**Consultation Response from KC,
Highways Development Management****2024/92727 Land adjacent to, Ashbourne Drive, Liversedge****Erection of residential development 67 dwellings with associated access, parking, public open space, landscaping and infrastructure****Date Responded: 16/01/2024****Responding Officer: Ryan Kinder****Responding Ref: K9-2NE-8**

2024/92727 Land adj Ashbourne Drive, Liversedge.

RECOMMENDATION: Further information requested as detailed in the comments below:

Drawing Title	Cross Sections		
Site	Ashbourne Drive, Cleckheaton		
Scale	1:1000 @A2	Date	19/09/24
Drawn	VB/MC	Checked	-
Drawing No.	Z168.007	Rev.	-
Thorpe Arch Grange Walton Road Thorp Arch LS23 7BA 01937 543599 www.newetthomes.co.uk

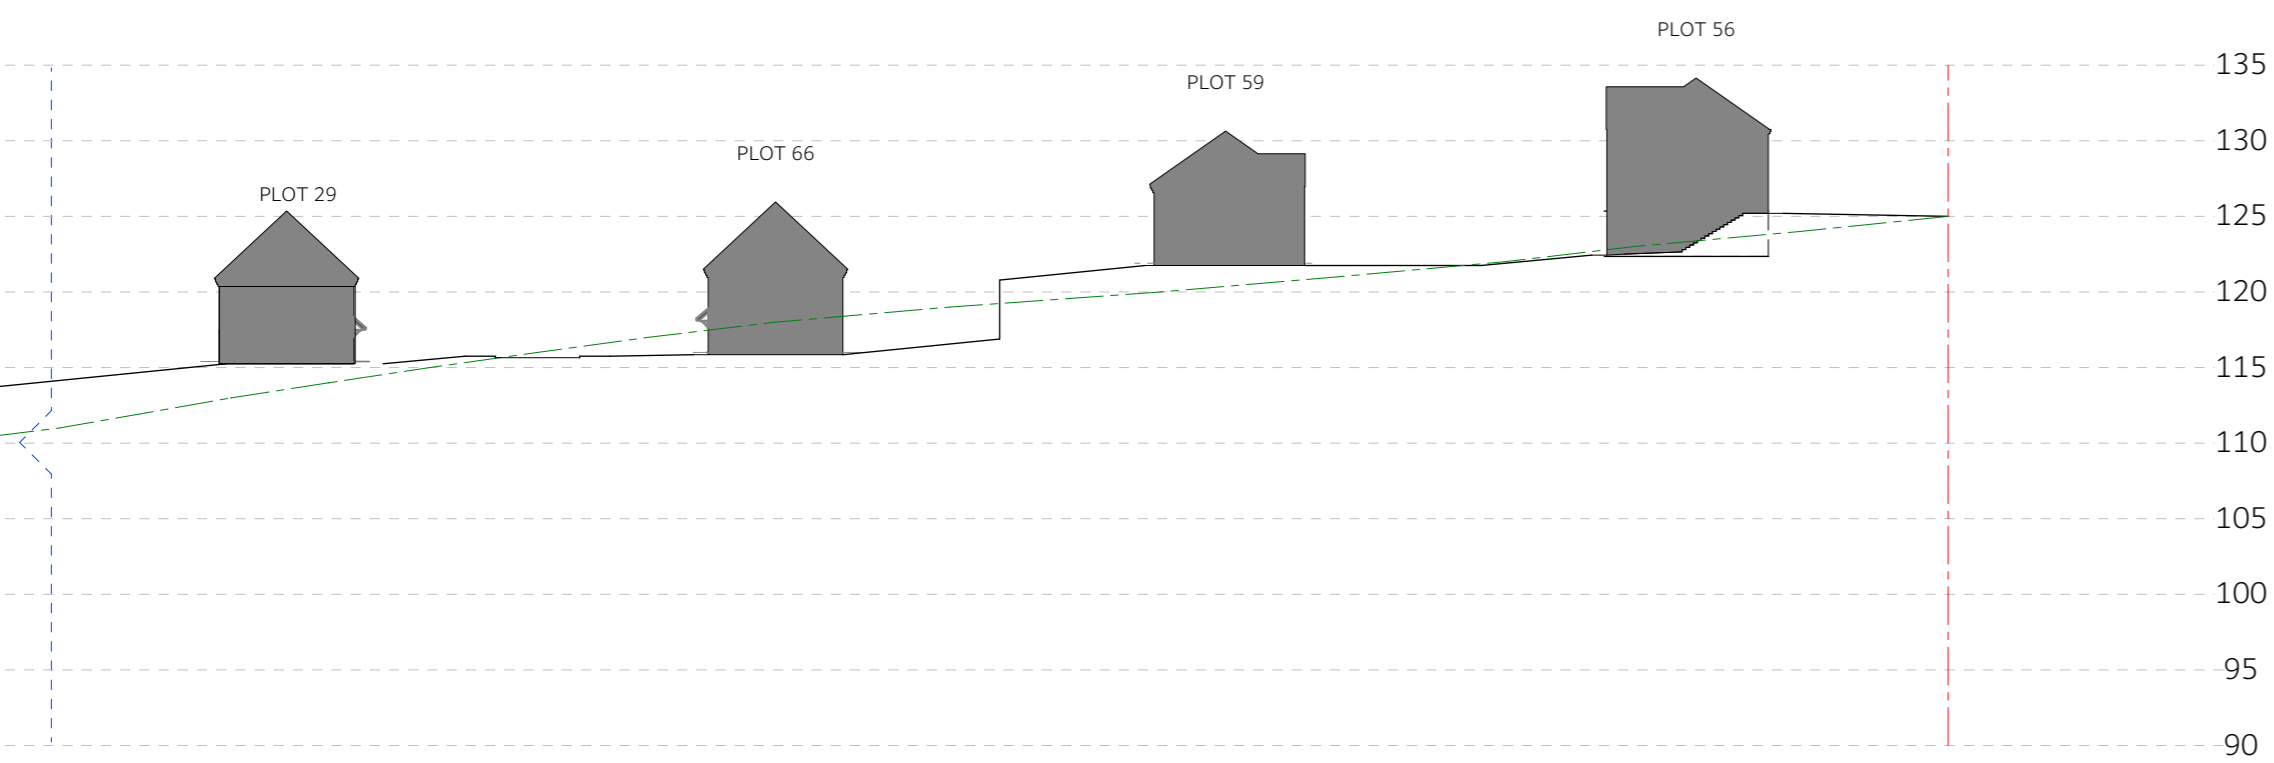
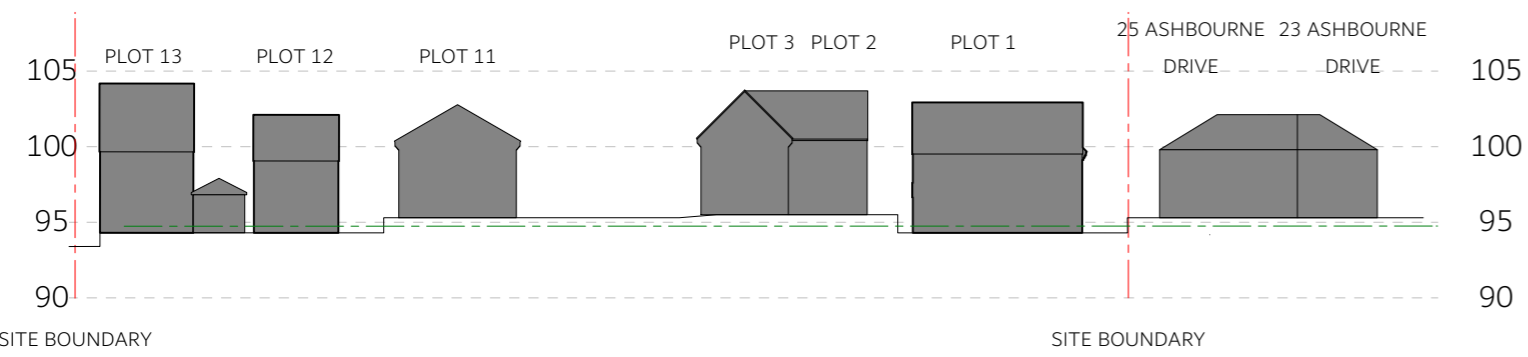
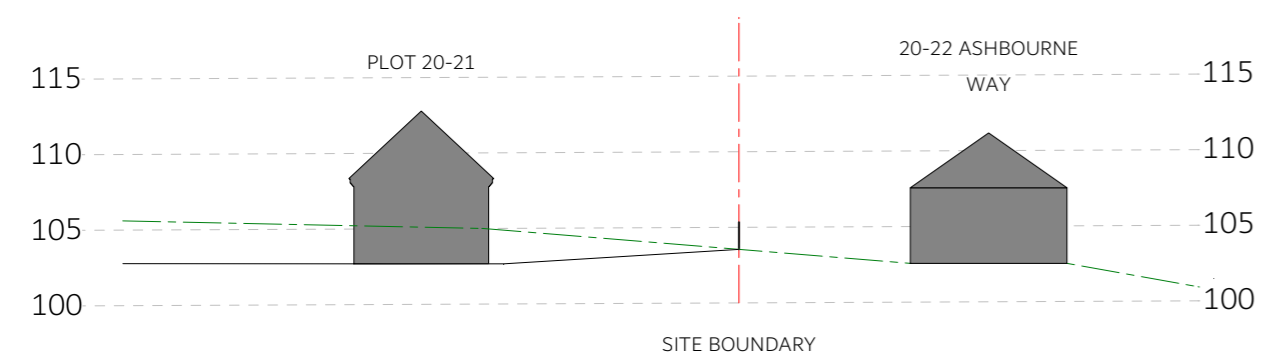
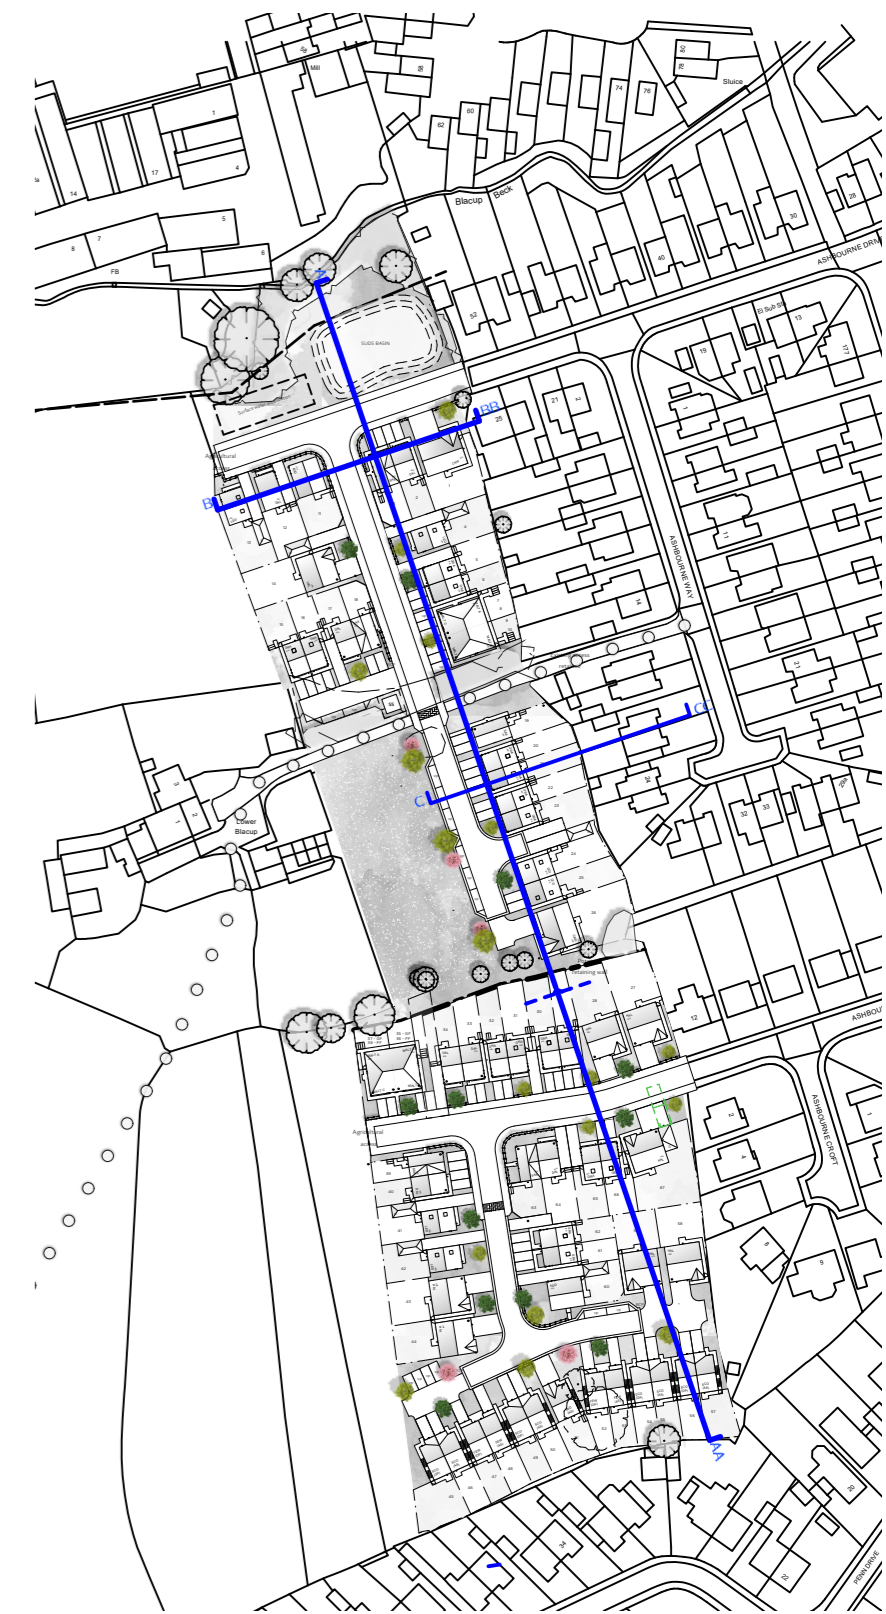
Clarification is sought on the intention of having the internal layout to be adopted by the Council, the proposed layout as it stands appears to be suitable for this in part, however the lower part of the site which appears to be a shared surface arrangement must not exceed a gradient of 1:20 to be acceptable for adoption. A long section indicating finished gradients is therefore requested.
